Subject Pasminco & Incitec Consolidated Remediation

Application for an increase in the volume and height of the onsite Pasminco & Incitec Containment Cell – Lake Macquarie City Council Submission

Subject: Pasminco Cockle Creek Remediation (06_0184 Mod 3)

Photo 12A: 3D image of the site with existing cell structures, viewed from the west with Munibung Hill in the distance to the east.

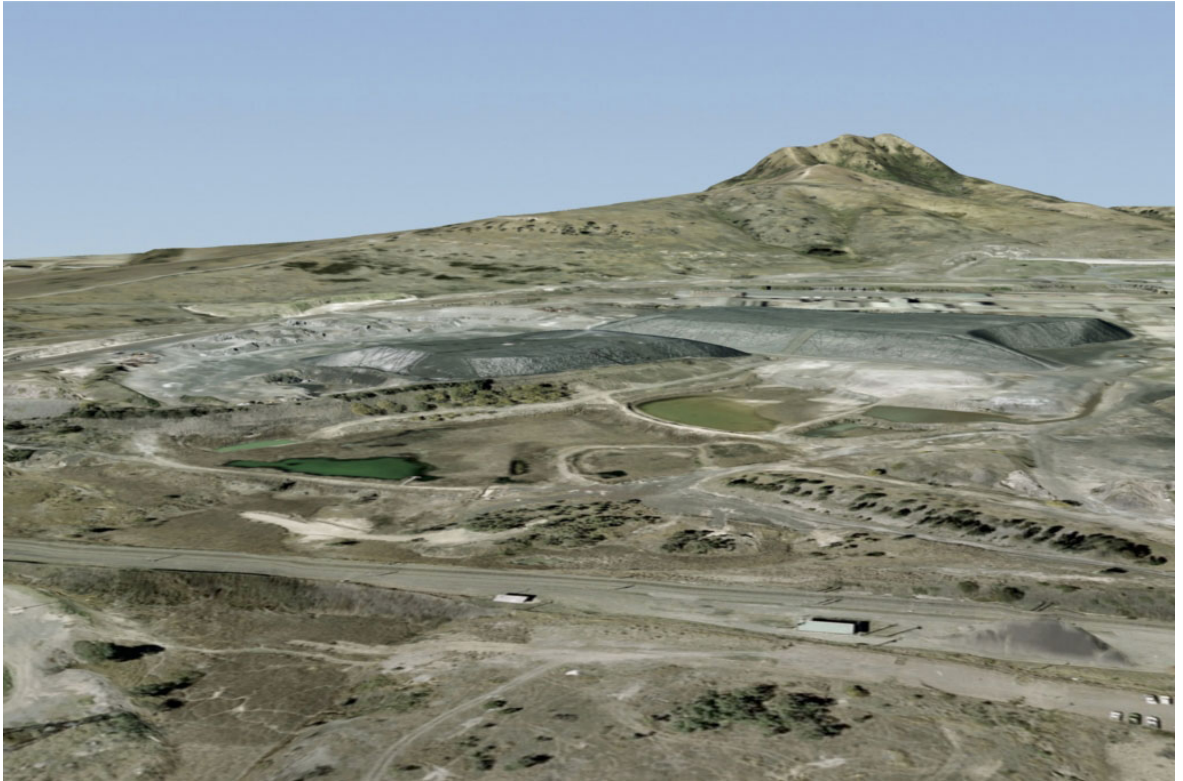
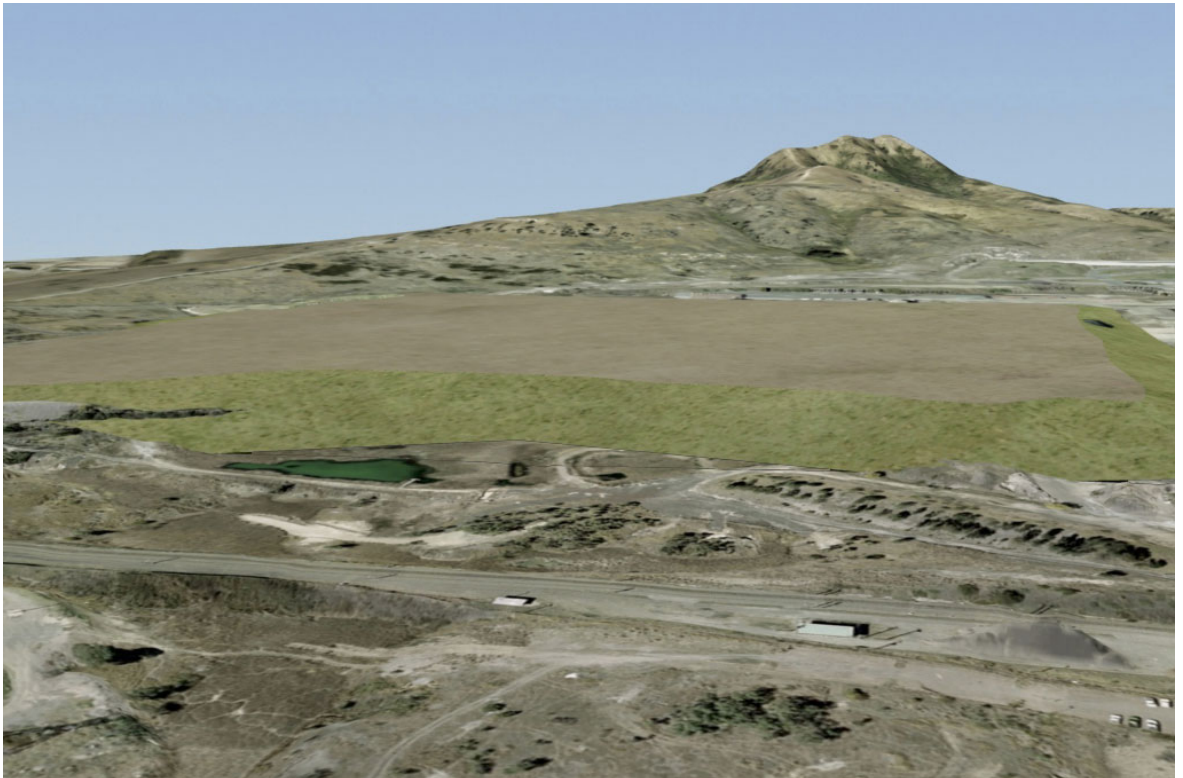
A 3D visual assessment of the comparing the mass and scale of the existing cell with the proposed cell indicates that the proposal would not significantly increase the visual mass and scale of the existing containment cell from distant views. Closer to the cell, the proposed height increase is more visually apparent, however, the visual impact will not be significantly different from the existing cell height

Figure 3: Concept of proposed cell capping system

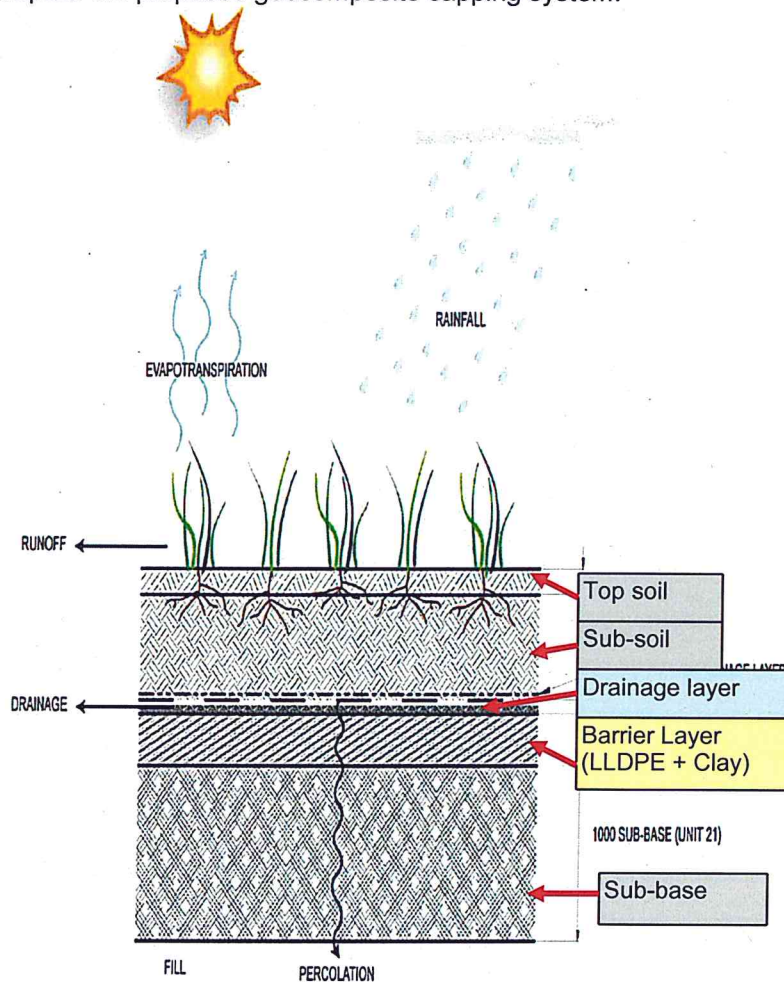
There are no objections to the proposed increase in volume and height of the approved Containment Cell from a contamination viewpoint provided the capping layer conforms to the approved specification, and/or the agreed modification, which Council reviewed and commented upon to Department of Planning and Infrastructure (DoP&I) in February 2012 (see attached).

There will be, in addition to the capping layer, drainage layer, 600mm of subsoil and 150mm of topsoil, which will support vegetative coverage and shrubs etc, however it is Council's understanding that trees will be precluded due to the potential for their root systems to breach the capping layer and infiltrate the encapsulated contaminants.

Council raises no objection to the provision of a composite capping layer to the remainder of the containment cell, but on the following understanding:-

A scaled site survey plan of the cell is produced which accurately identifies and delineates both the existing 600mm and proposed composite capping layer on completion.
